Lime Down Solar Park

**Planning Inspectorate Reference:
EN010168**

**Wiltshire Council Comments on Submissions
Received at Deadlines 1 and 1A**

Deadline 2 (22 May 2026)

Title: Figure 9.1.14: Baseline Habitats Map - Cable Route Corridor (2 of 12)

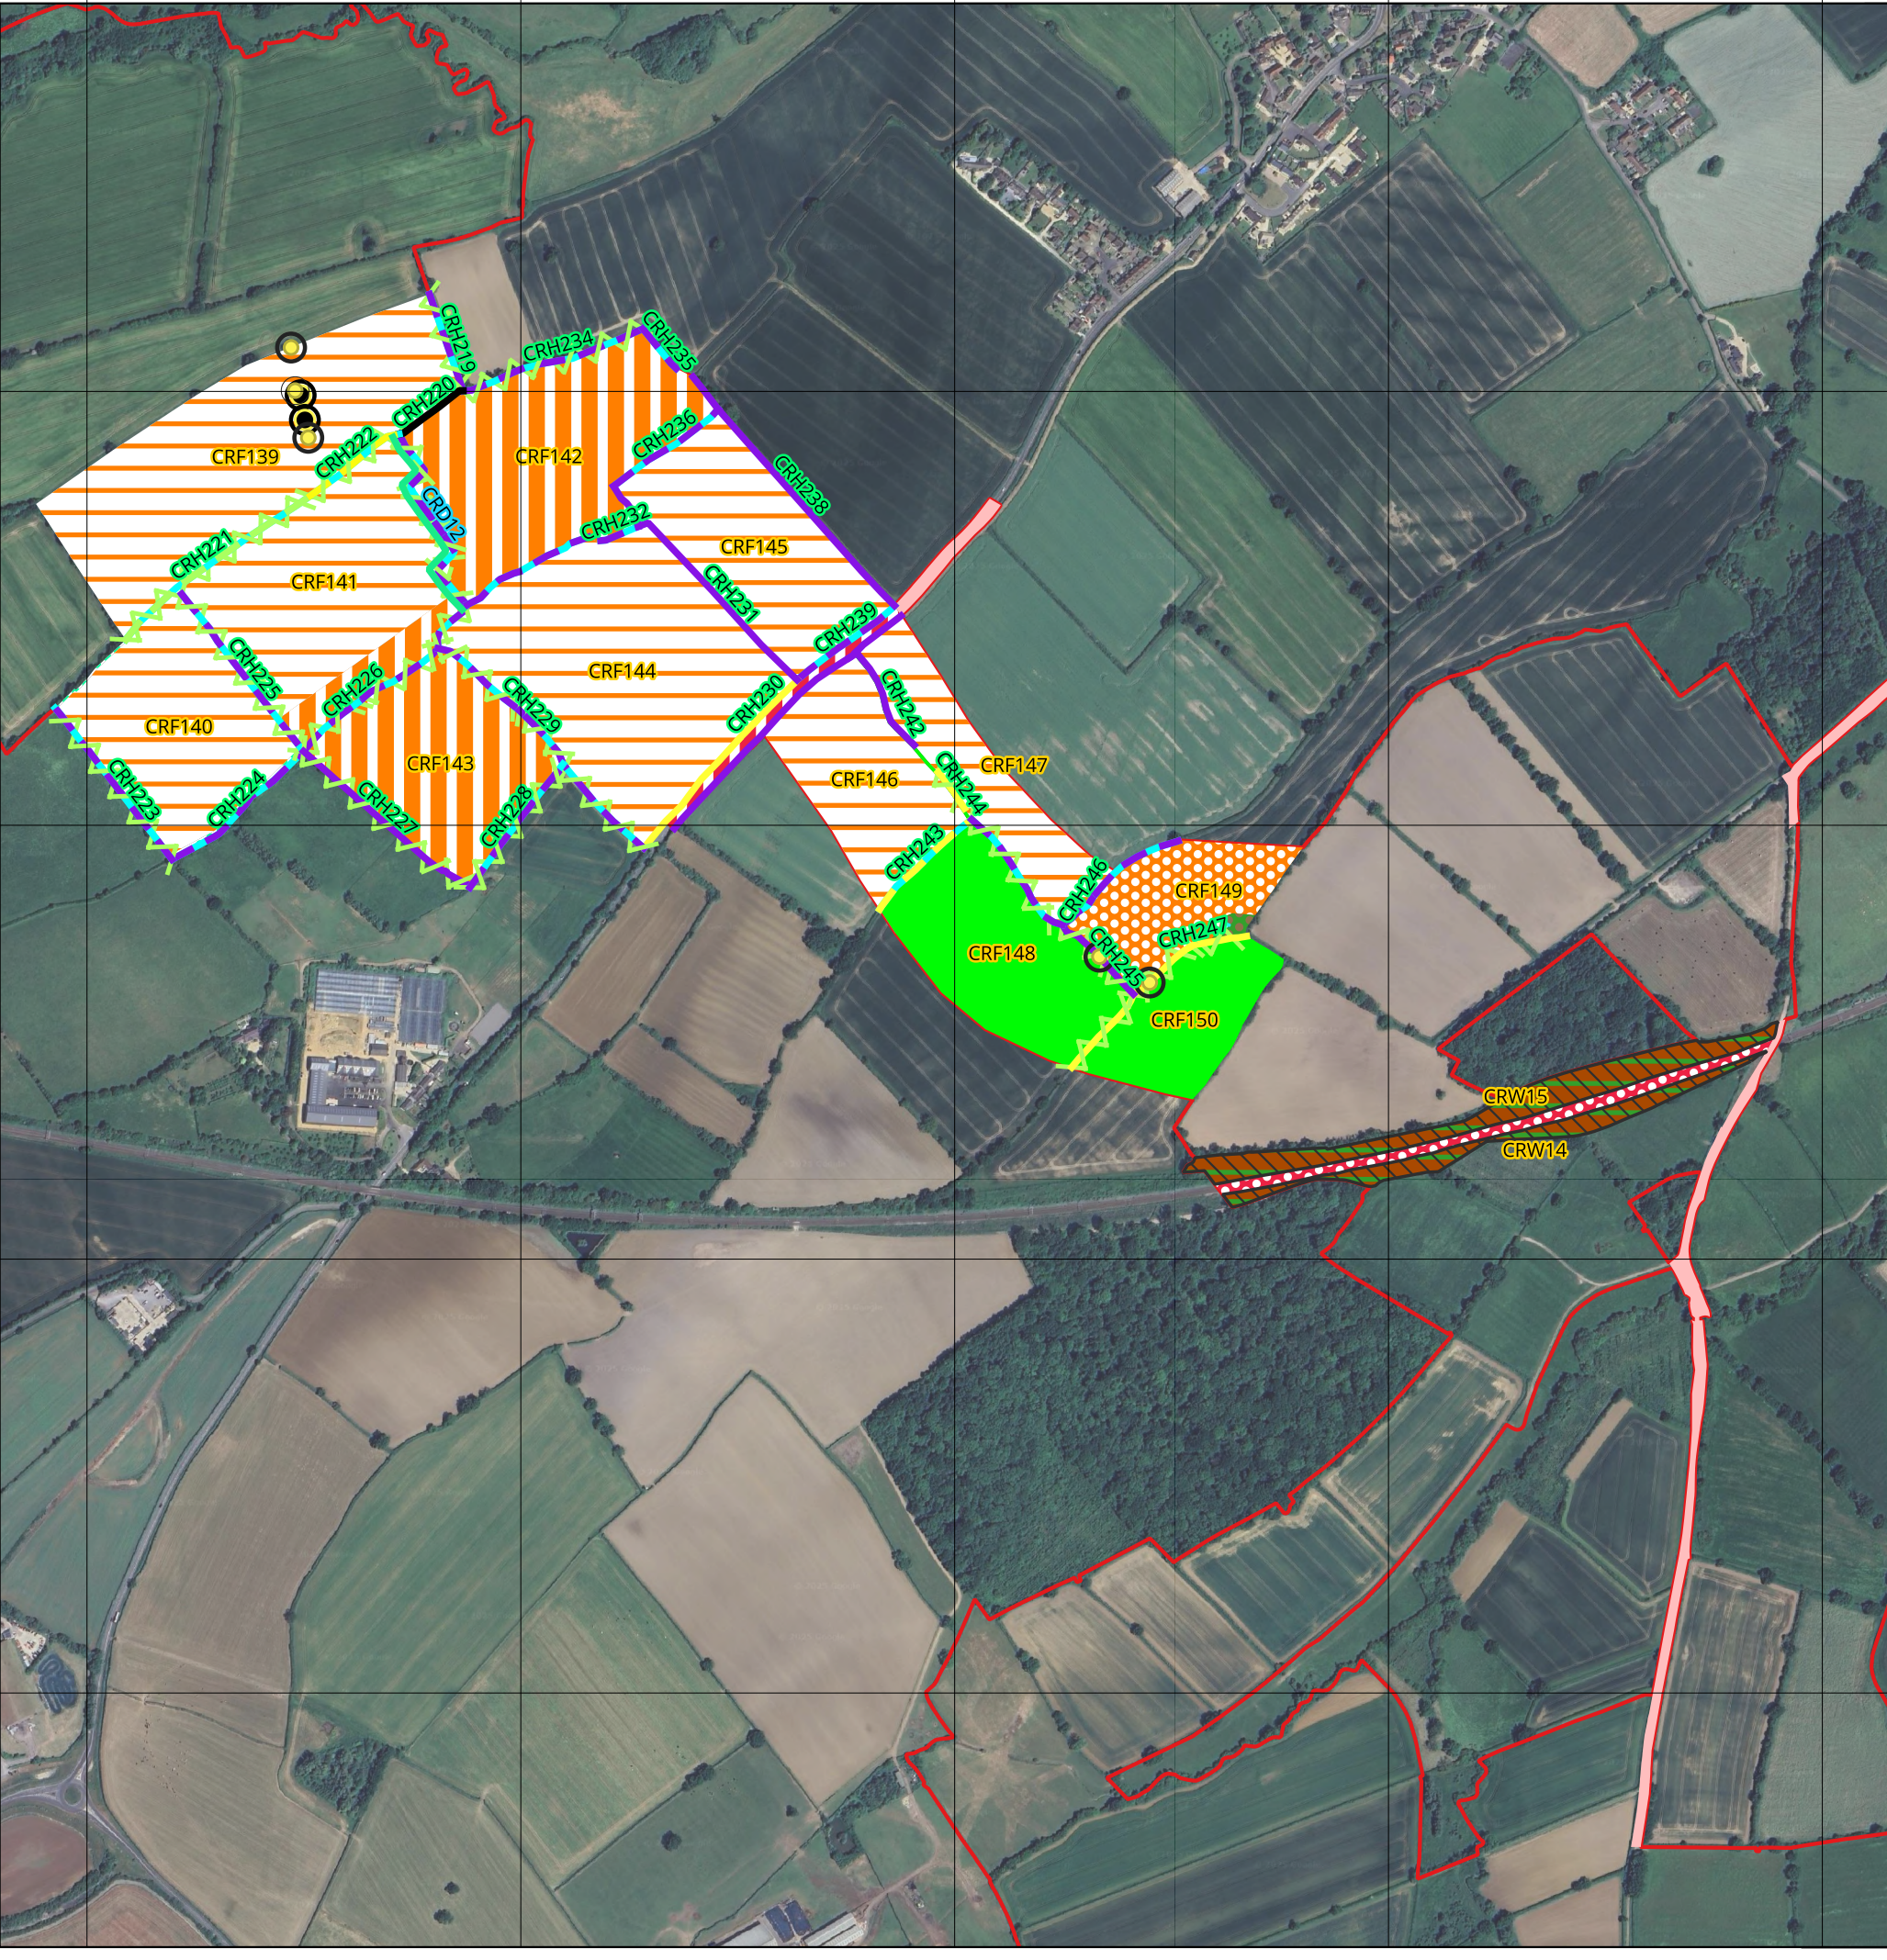
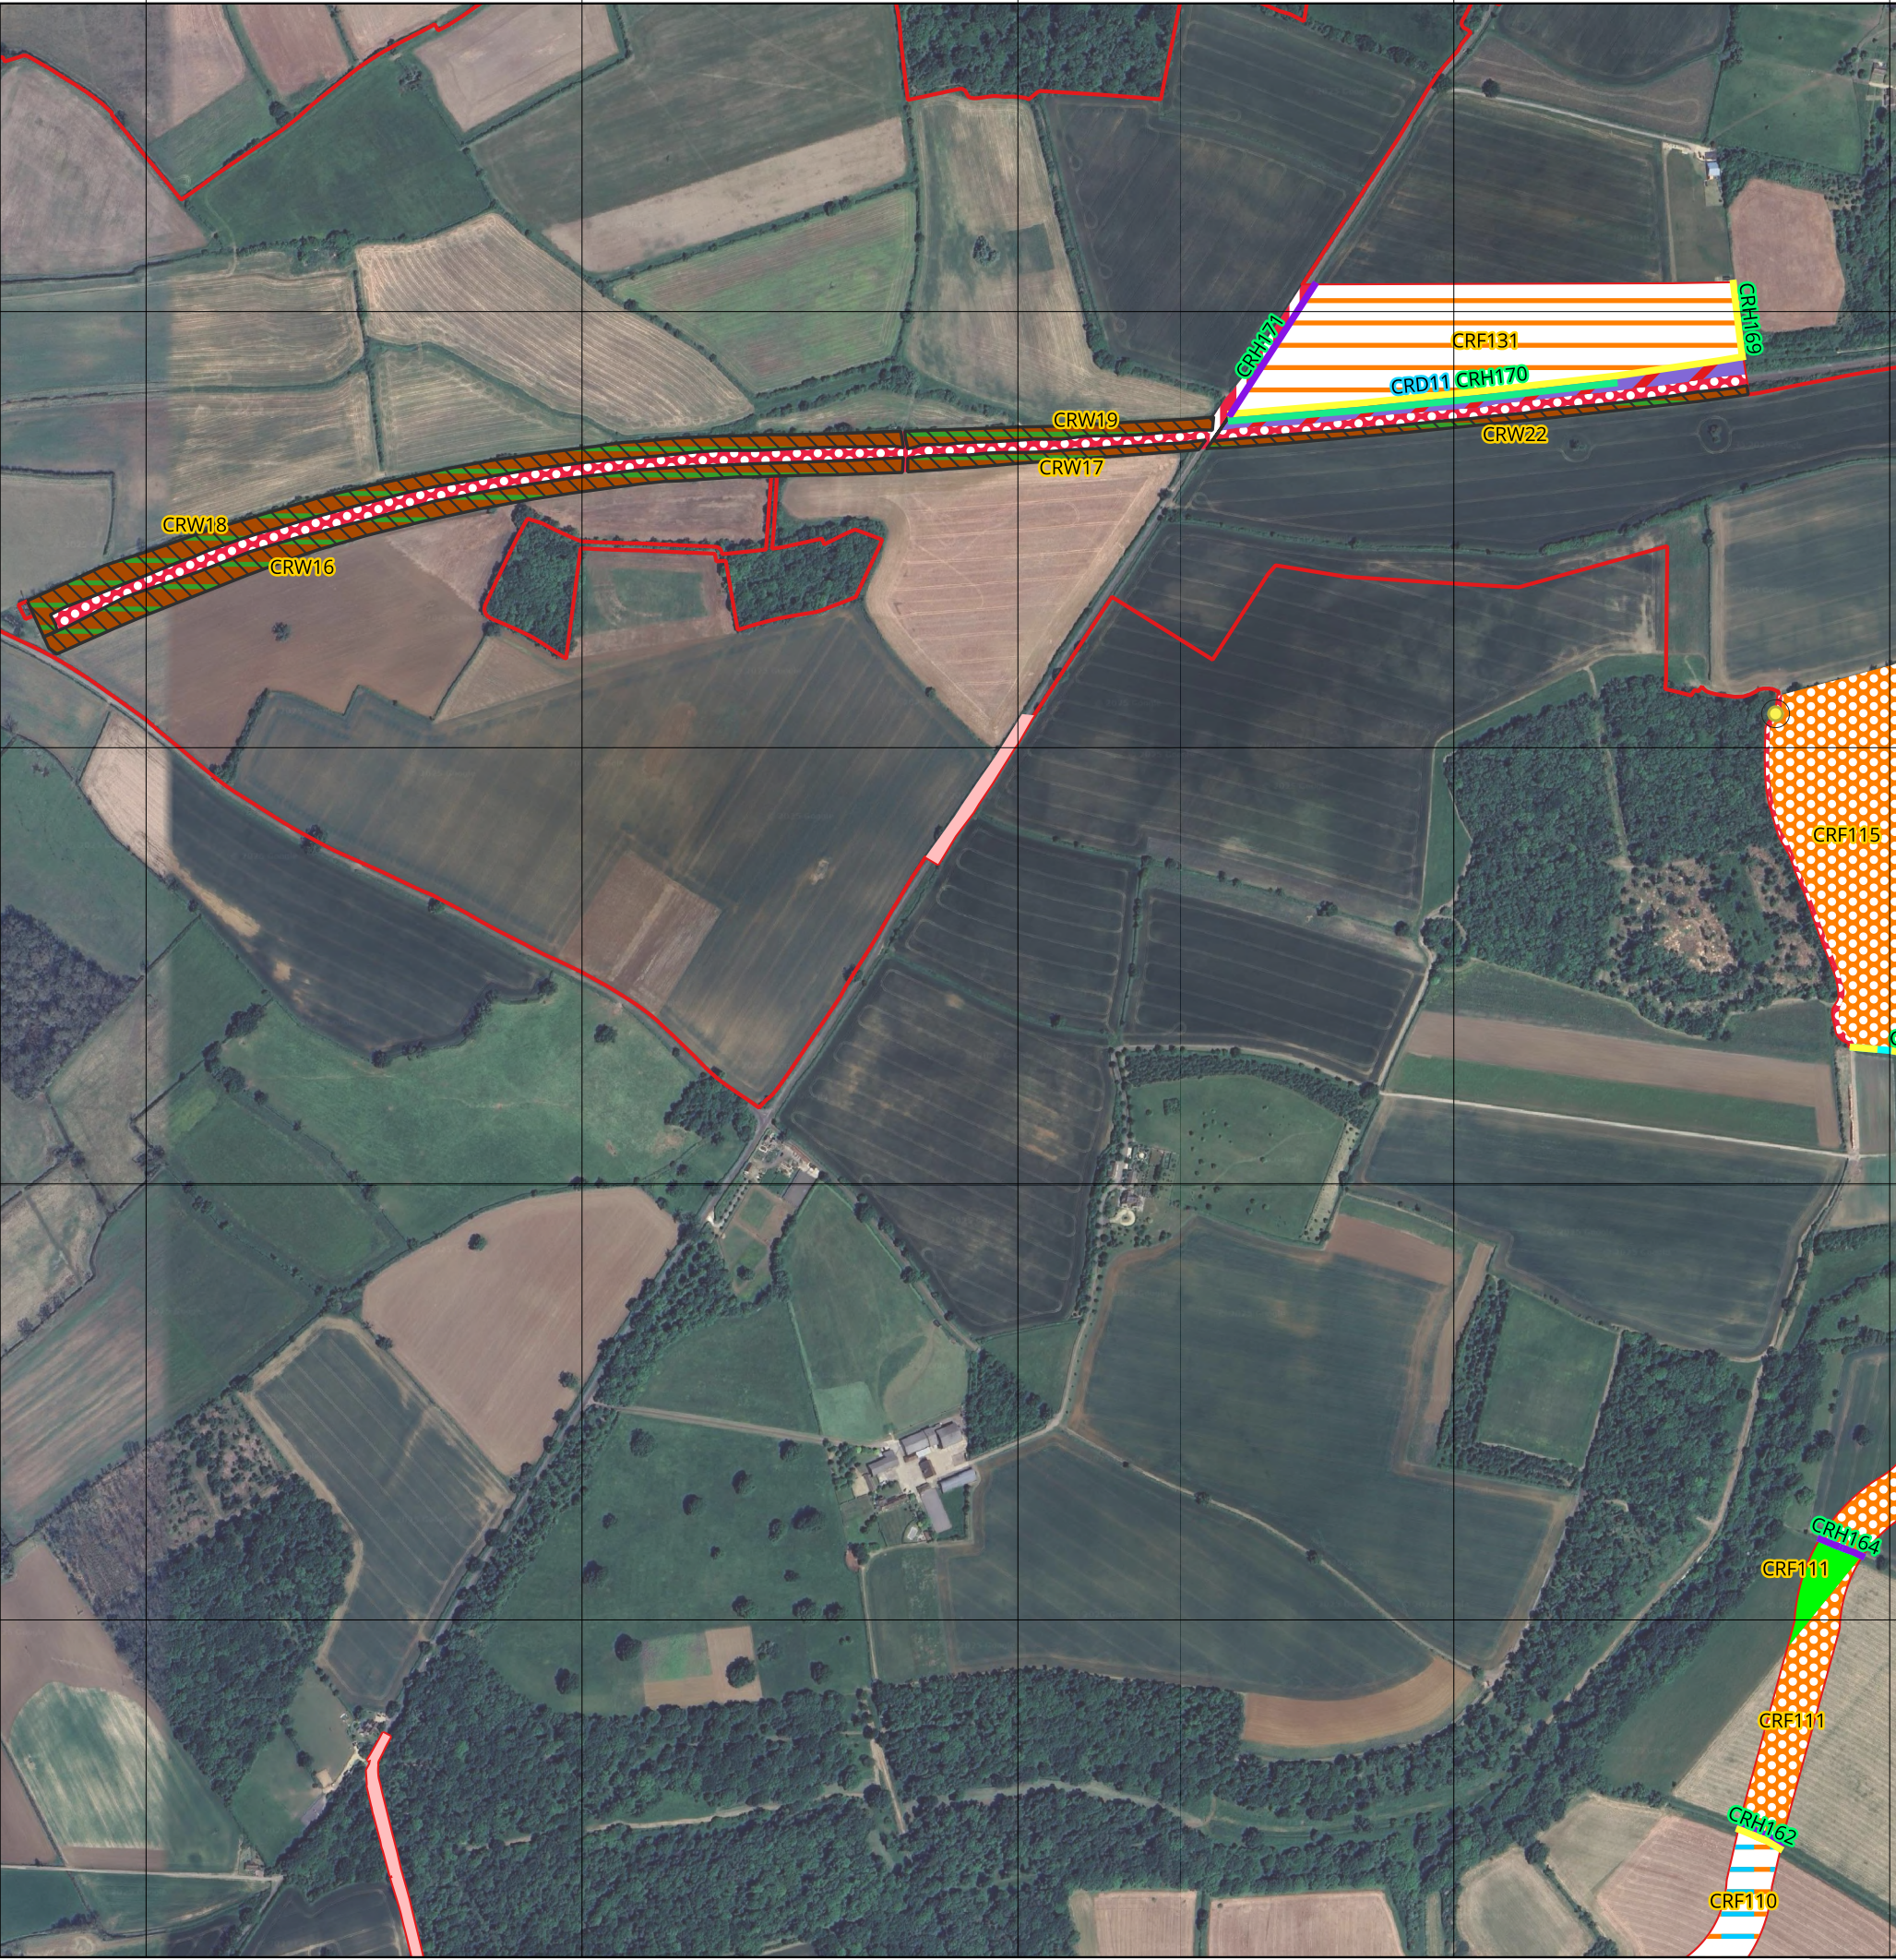
- 5.1. In respect of other neutral grassland (ONG), it is noted that revisions to **Table 9-8** and **Paragraph 9.10.100** indicate a reduction in the estimated area of ONG present within the cable route corridor from 15.44 ha as detailed in the last iteration of ES Chapter 9, to 3.06 ha in the Rev 2 iteration submitted at Deadline 1.
